Notice of Exhibition for Project EnergyConnect (NSW - Eastern Section) (SSI-9172452)

Thank you for your referral dated 17 January 2021 inviting comments from the Heritage Council of NSW on the above State Significant Infrastructure (SSI).

- *Technical Paper 3 – Historic Heritage Impact Assessment*, Navin Officer, December 2021 ('HHIS')

Figure 5.4 Listed historic heritage items in the historic heritage study area – map 2a (Yanga)

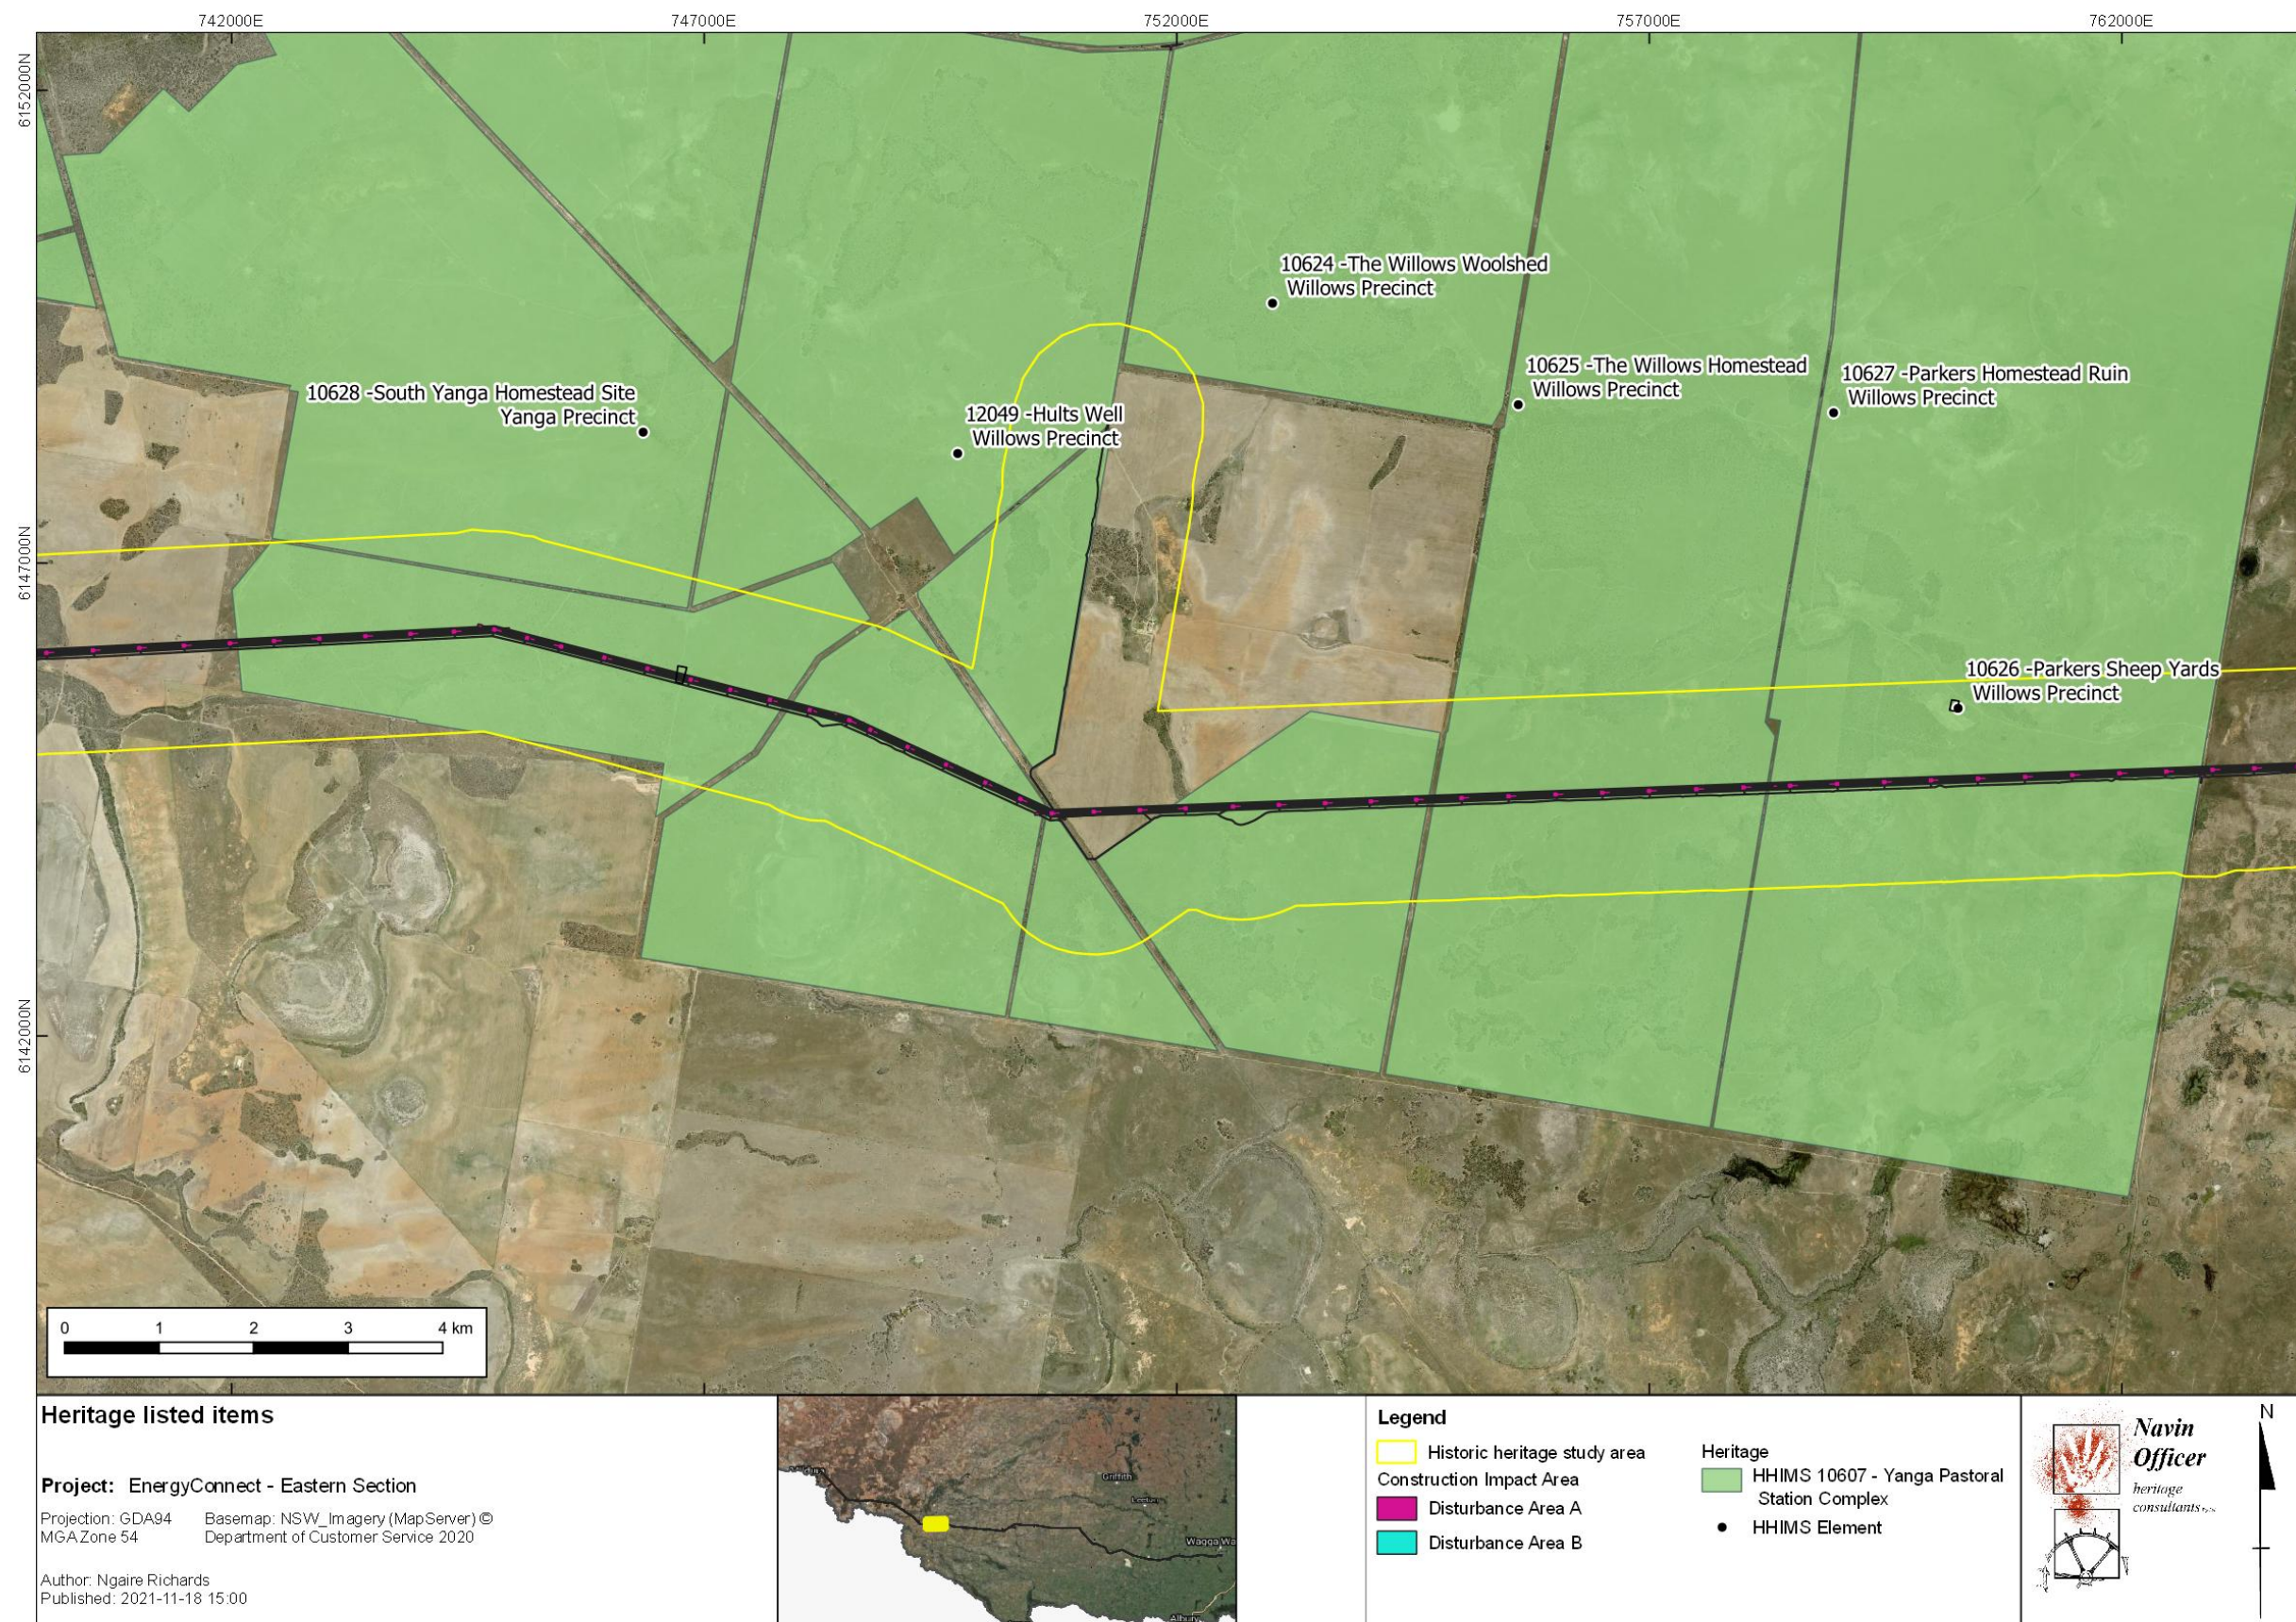
- The HHIS notes that, if harm to the sheep yards on the Yanga Pastoral Station cannot be avoided, consultation with NPWS would occur, and that where requested, archival recording of the sheep yards would occur and be provided to NPWS. This is supported and should be included as a condition of consent.

Figure 5.12 Potential historic heritage items

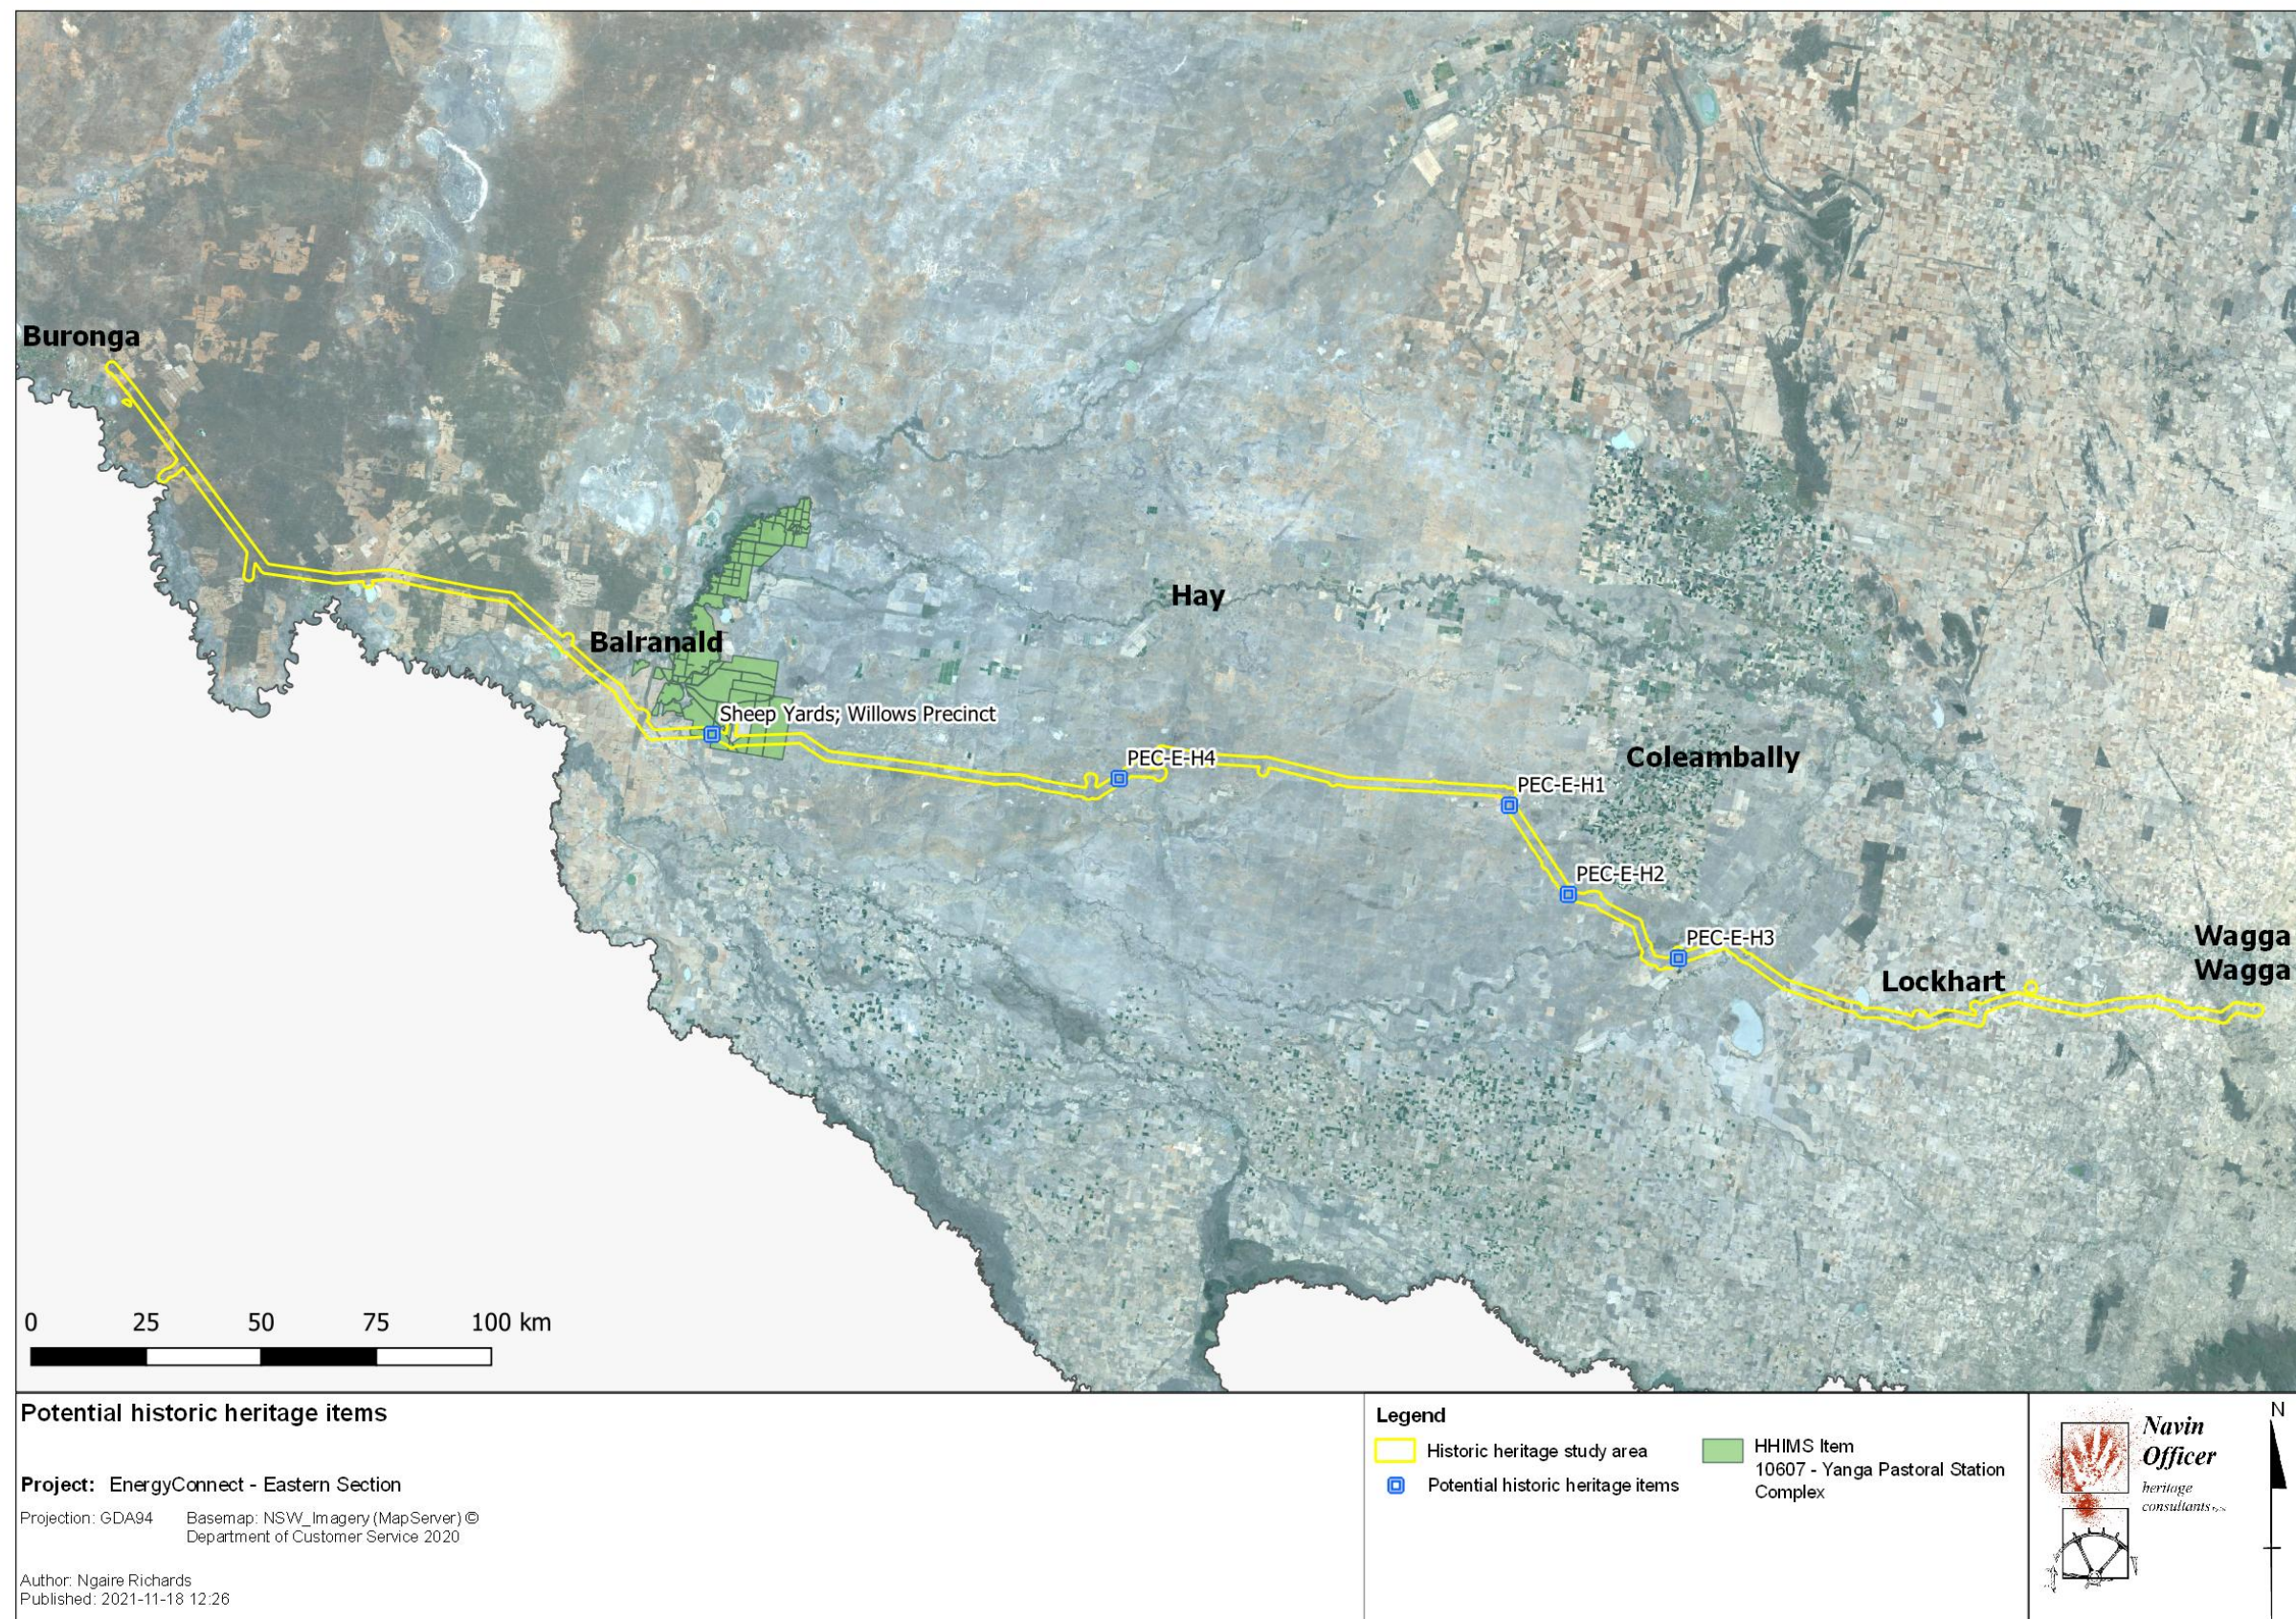
- The HHIS recommendation regarding temporary fenced exclusion zones around the impacted sites is supported and should be included as a condition of consent.
- As the hut site has been identified through desktop research only, the HHIS notes that an archaeological survey will occur when access is available to determine if the

structure is extant, any associated archaeological potential and any potential for impact. This should be provided to HNSW to comment upon with RTS stage. The HHIS also notes that design finalisation will attempt to avoid/minimise direct impacts to the item, including options for siting the tower and access track. This is supported.
